Your Ref: OWPC7182
Our Ref: AW/267/15/HH 04-09-2015
Please ask for:
Mr D Easton

Minor Amendments to previously approved application AW/344/14/HH for extensions & alterations - This application affects the character and appearance of the Craigweil House Conservation Area.

68 The Drive Aldwick

PROPOSED FIRST FLOOR PLAN 1:100

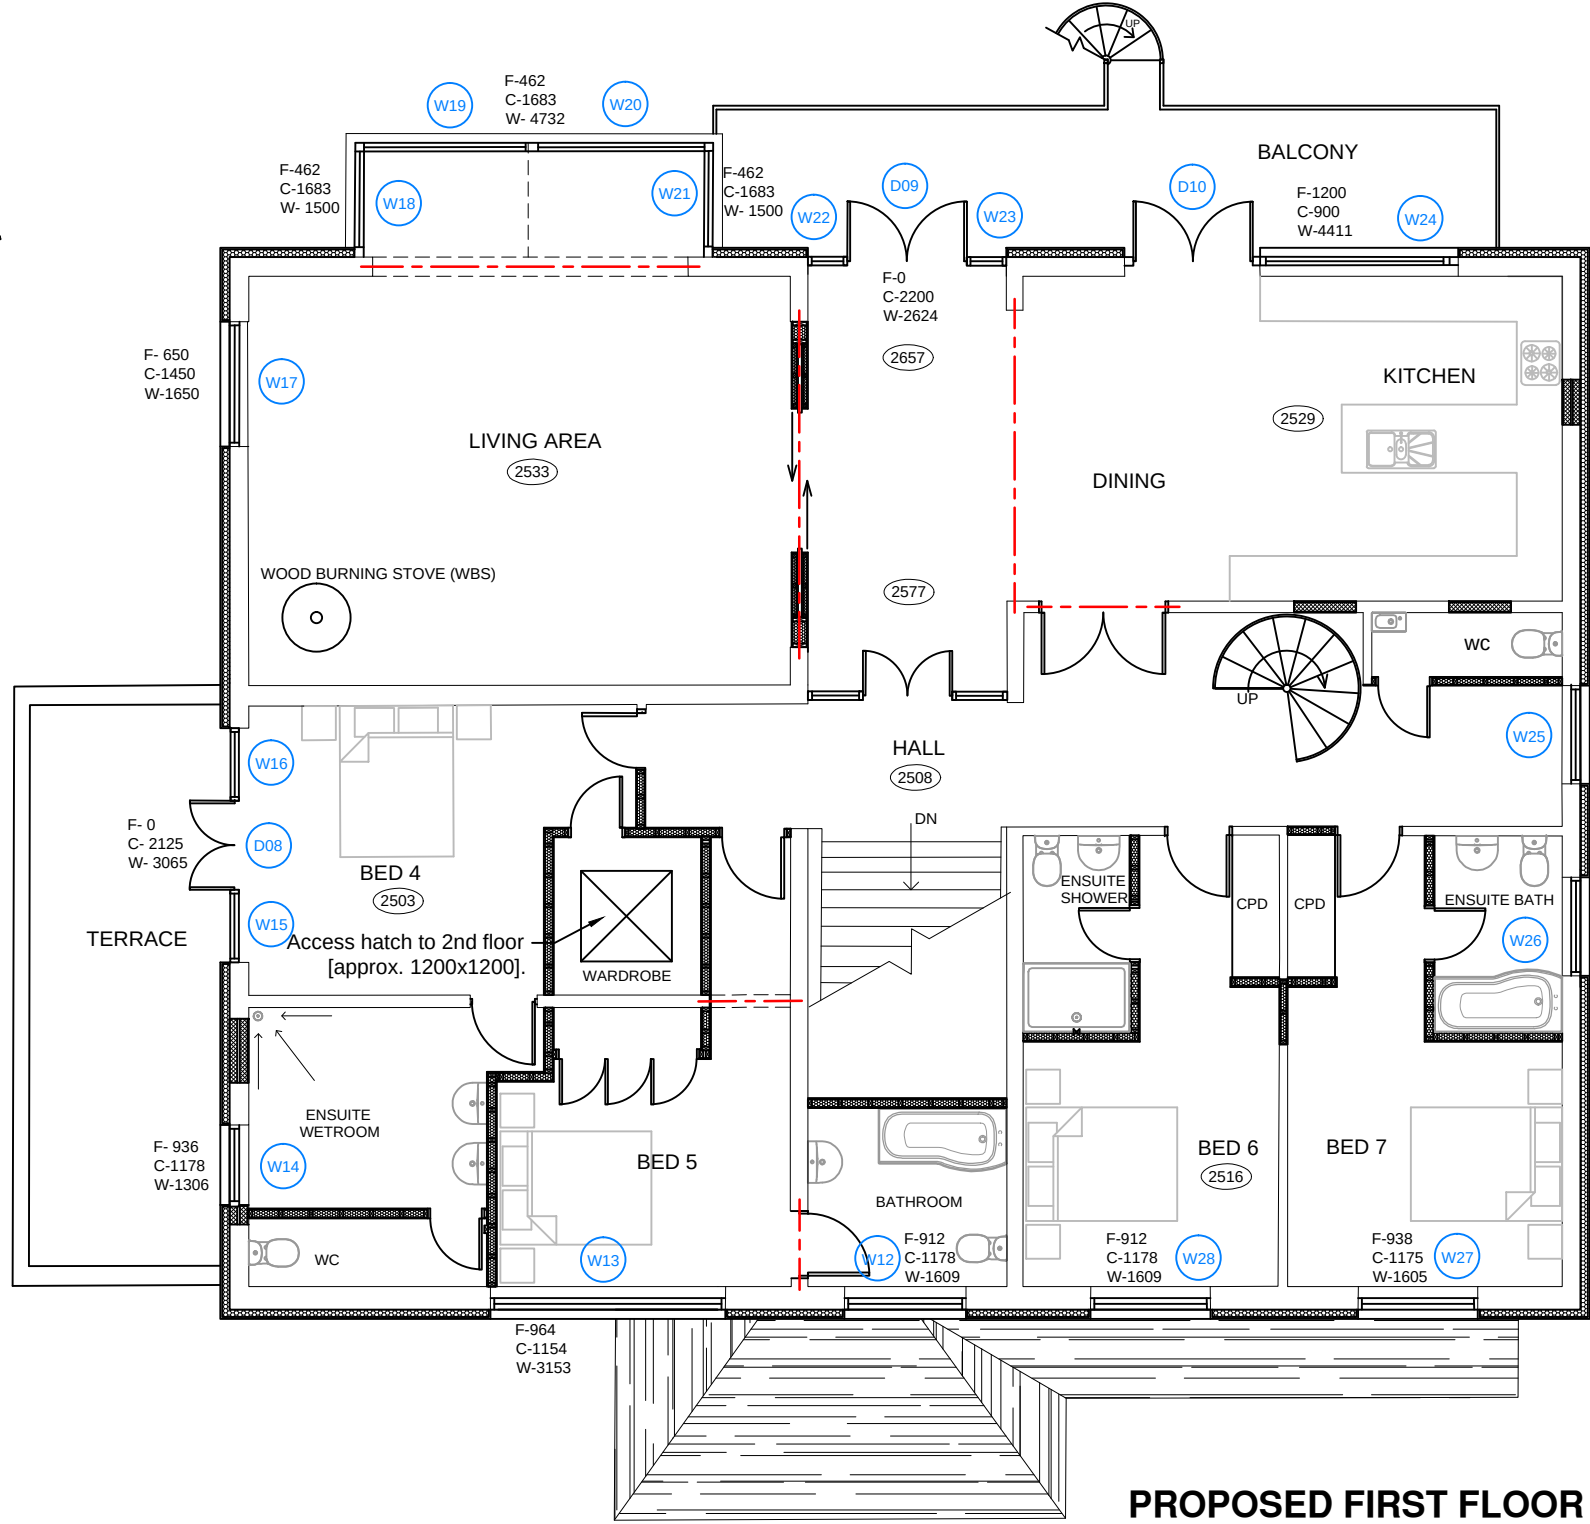
We note now, however, that the plans for the internal refurbishment of 68 The Drive have altered, and what are currently the kitchen and dining room on the first floor eastern elevation are to become a bedroom and bathroom. In that circumstance we question whether there is any need for a terrace on the first floor eastern elevation. The changed plans propose moving the kitchen and dining room to the western end of the rear elevation with an external spiral staircase outside the kitchen giving access to the rear garden.

Since external access has now been proposed for the rear elevation, we question how a first floor terrace giving external access from a bedroom can be justified when weighed against the excessive intrusion into our privacy that it would create.

PROPOSED EAST ELEVATION 1:100

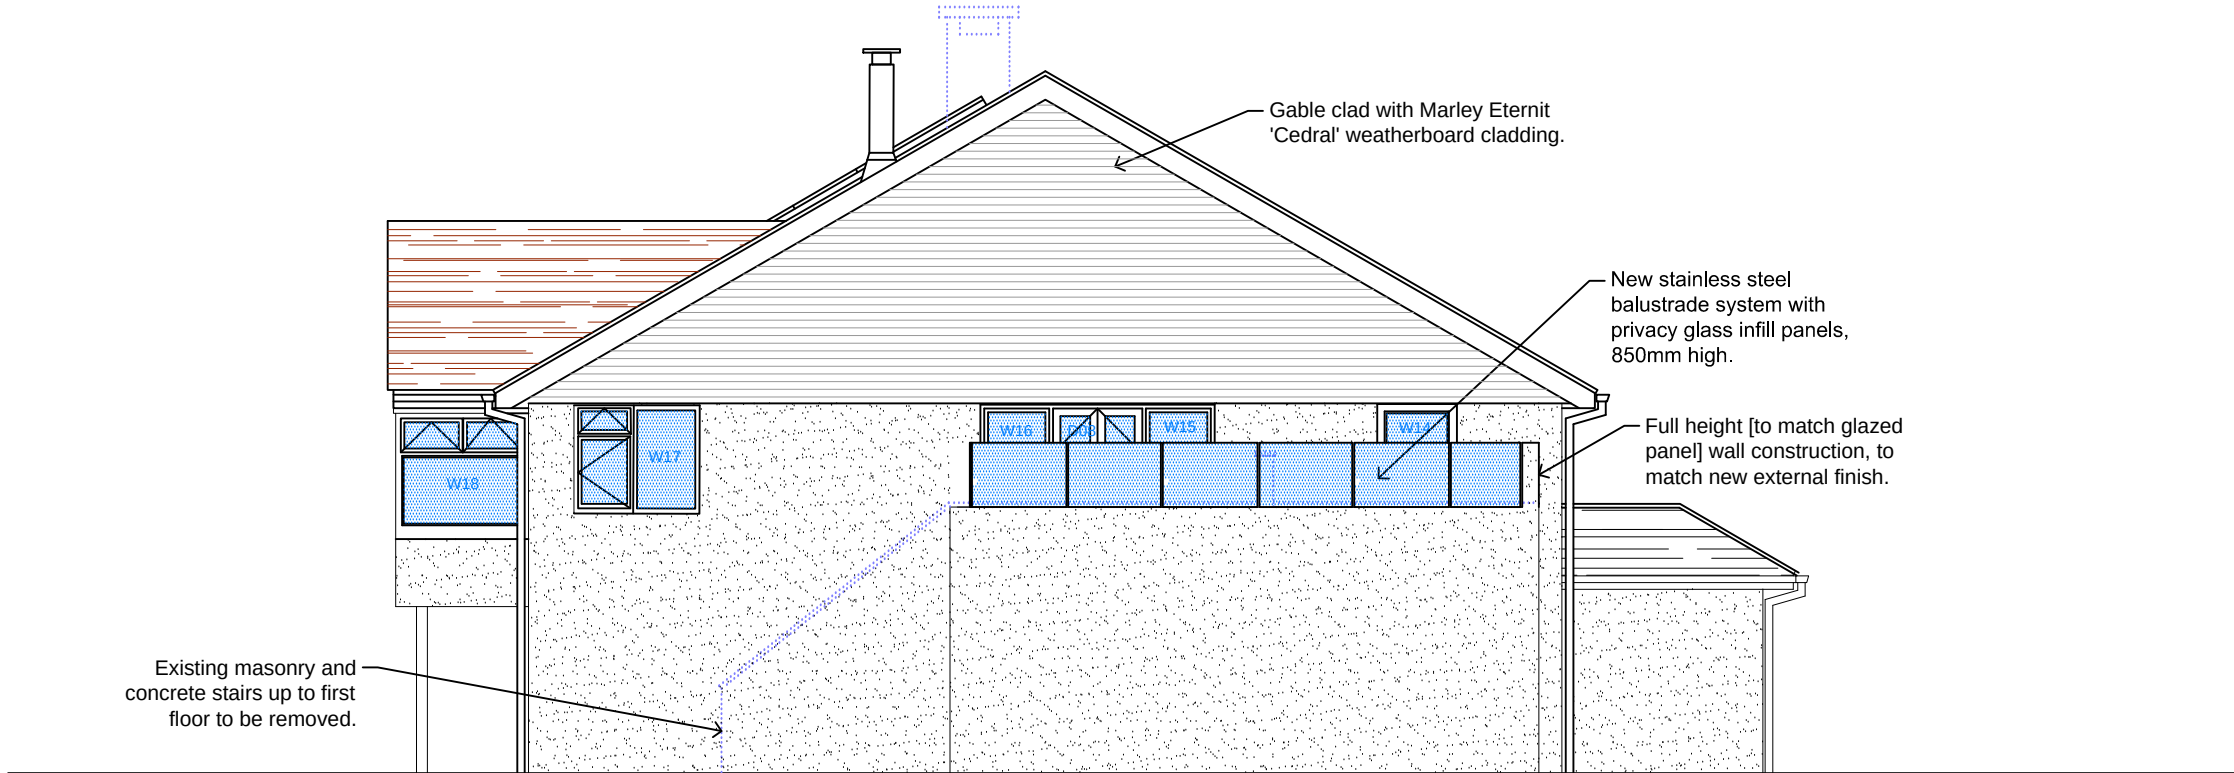
Our property abuts No. 68 The Drive on its eastern boundary. We objected to various elements of the original planning application AW/344/14/HH, but principally to the construction of a first floor terrace on the eastern elevation which would overlook our bedrooms. At the time of our objections, the terrace and its staircase would have given external access to the rear garden from the kitchen and dining room at No. 68. We felt the terrace would significantly impact on our privacy and seriously affect our quality of life in terms of noise nuisance.
